WEST SUSSEX COUNTY COUNCIL CONSULTATION

TO:	Arun District Council FAO: Maria Tomalova
FROM:	WSCC - Highways Authority
DATE:	29 June 2021
LOCATION:	Flat 1-3, Clayton House, Elm Grove, Bognor Regis, PO21 2SW
SUBJECT:	BR/134/21/PL Sub-division of existing four-bedroom flat on first and second floors to create 2no. 1-bedroom flats, insertion of three dormer windows at second floor, insertion of rooflights to north and south elevations and removal of window to western elevation. This site is in CIL Zone 4 (Zero Rated) as flats.
DATE OF SITE VISIT:	N/A
RECOMMENDATION:	Advice
S106 CONTRIBUTION TOTAL:	N/A

Drawing Title:
Block & Location Plans
Site Plan
As Existing & Proposed

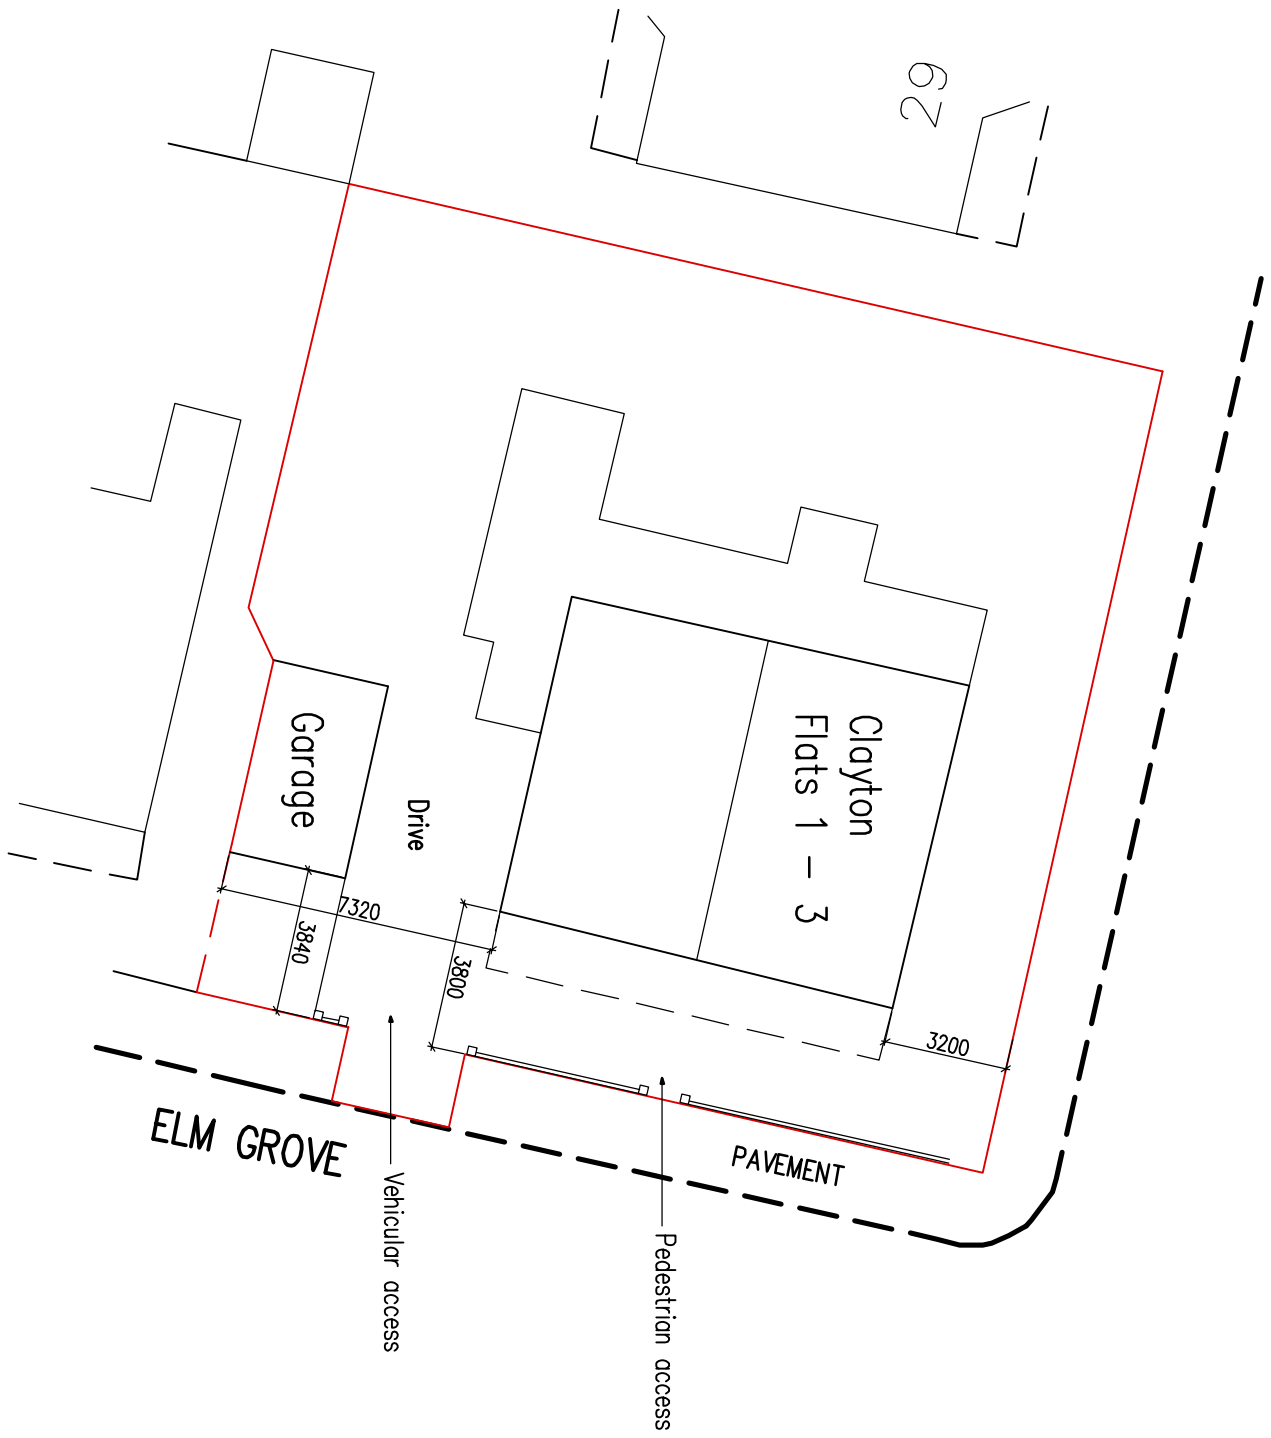
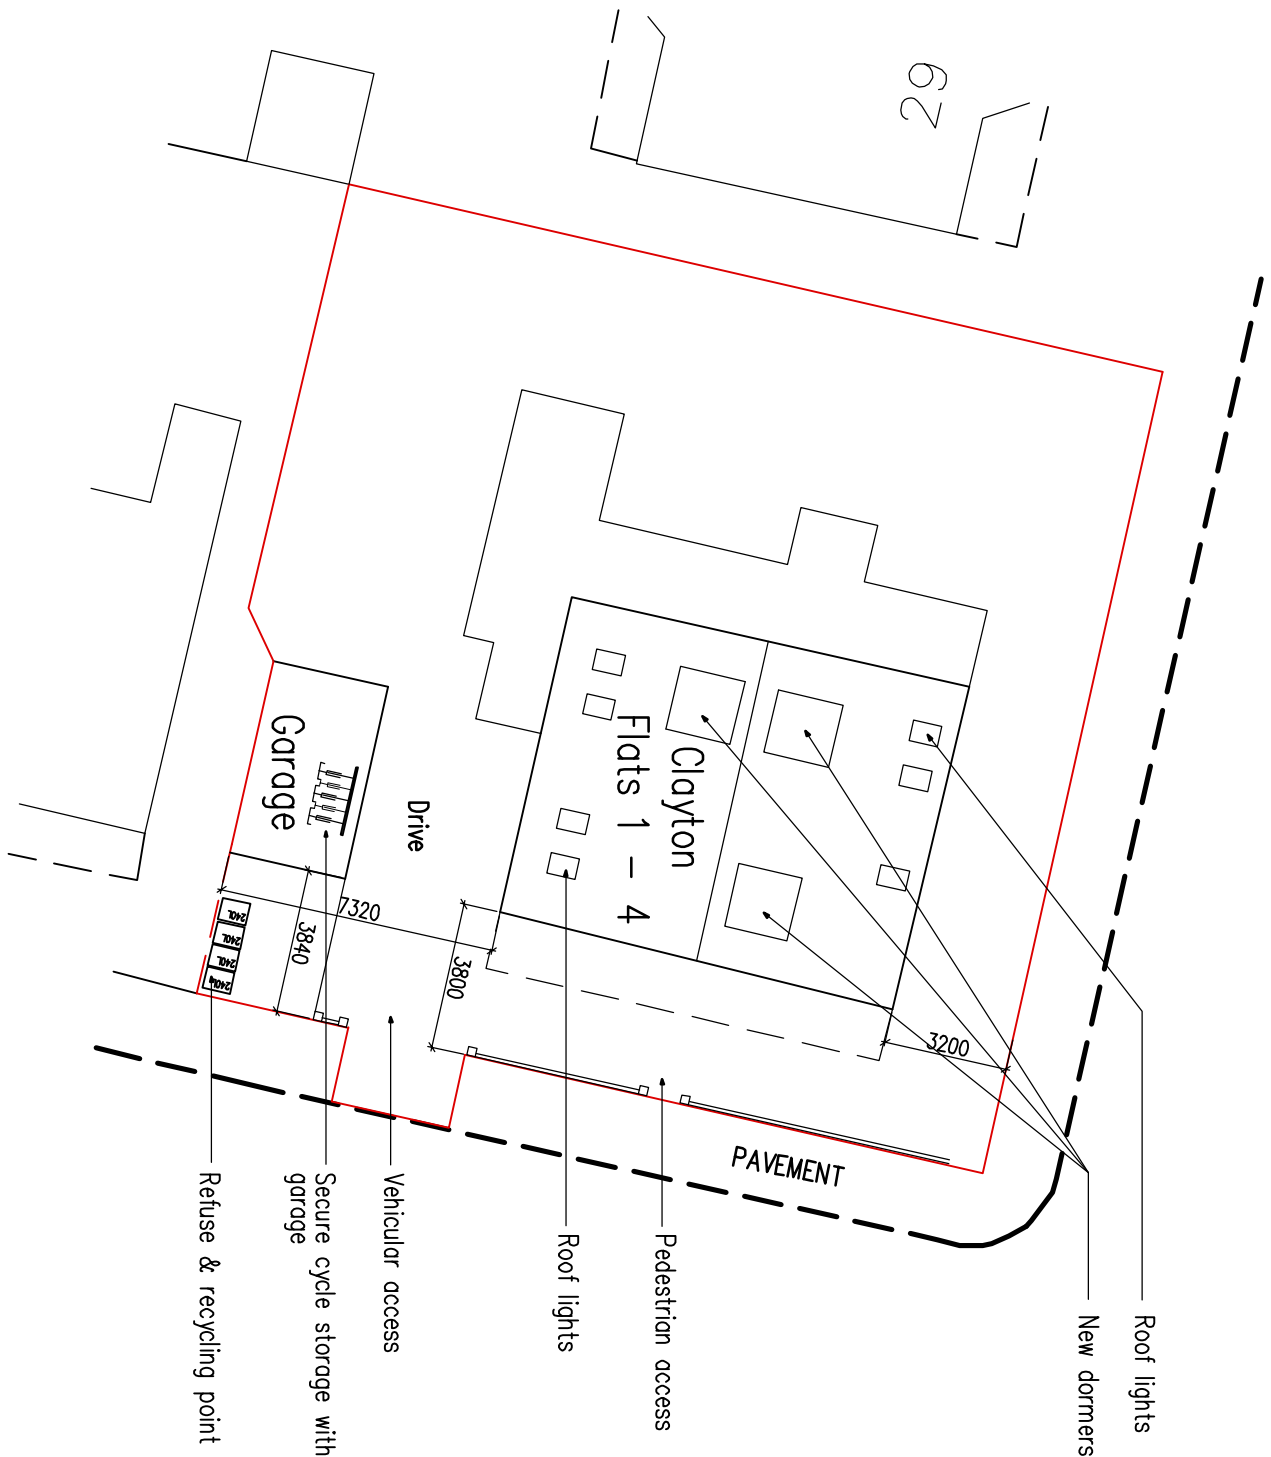
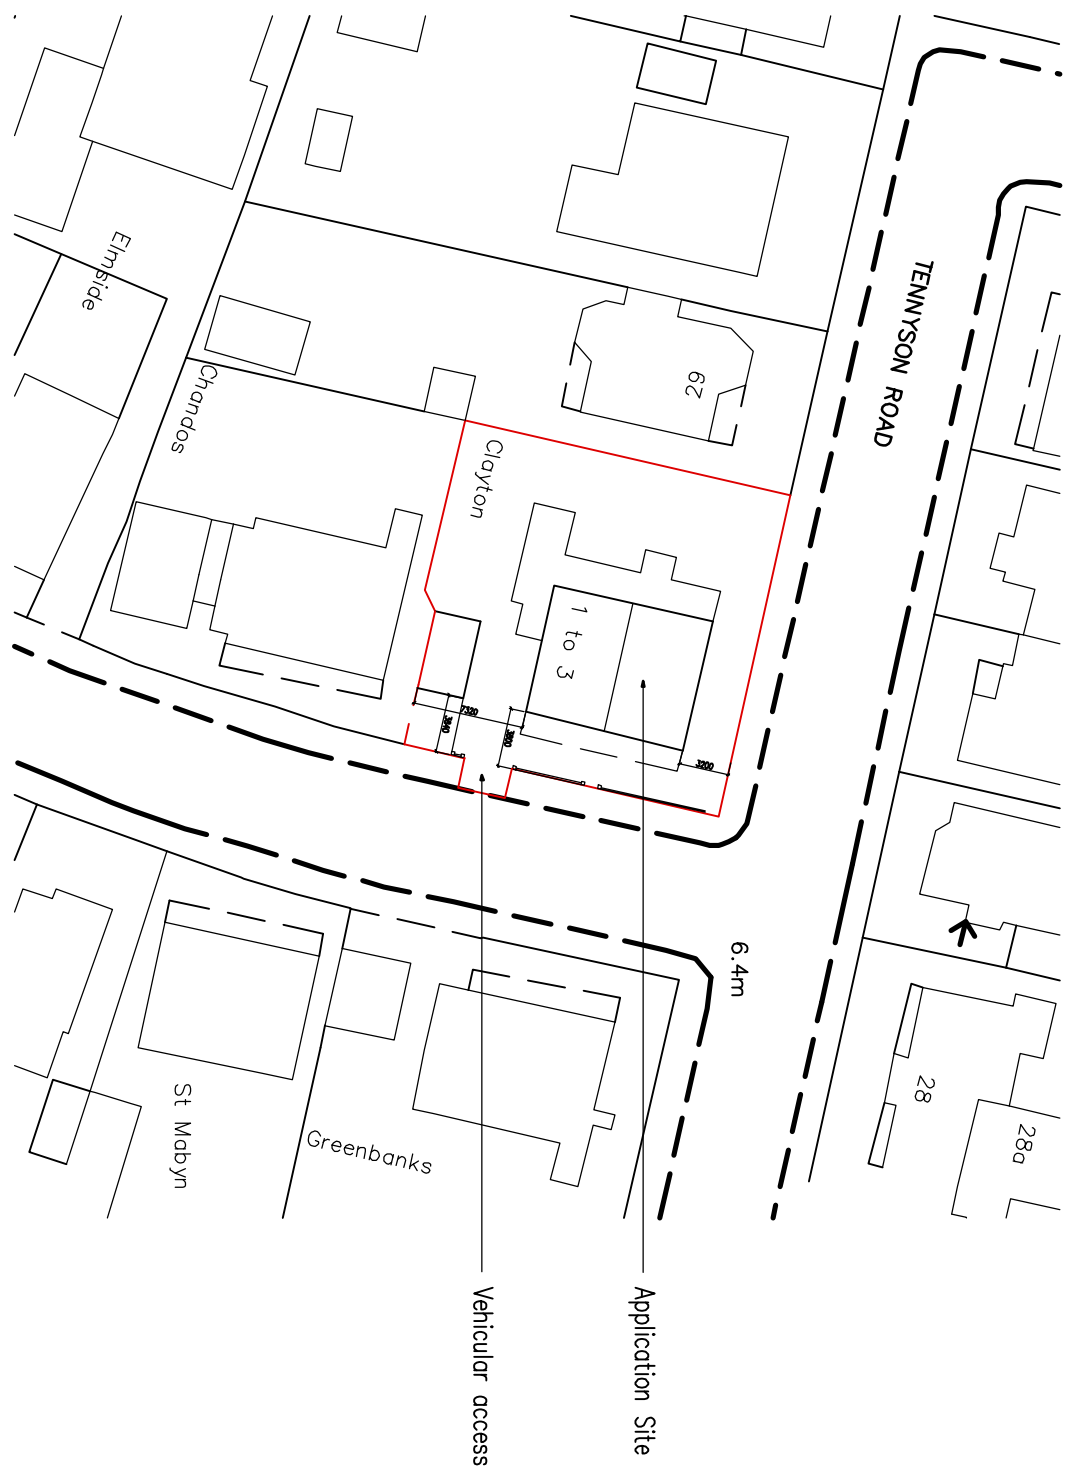
The applicant has stated that the existing garage will be utilised for secure and covered cycle parking provision. The garage is of suitable size to provide cycle parking for each unit, in accordance with Arun Parking Standards. The inclusion of cycle parking helps promote the use of sustainable transport methods.
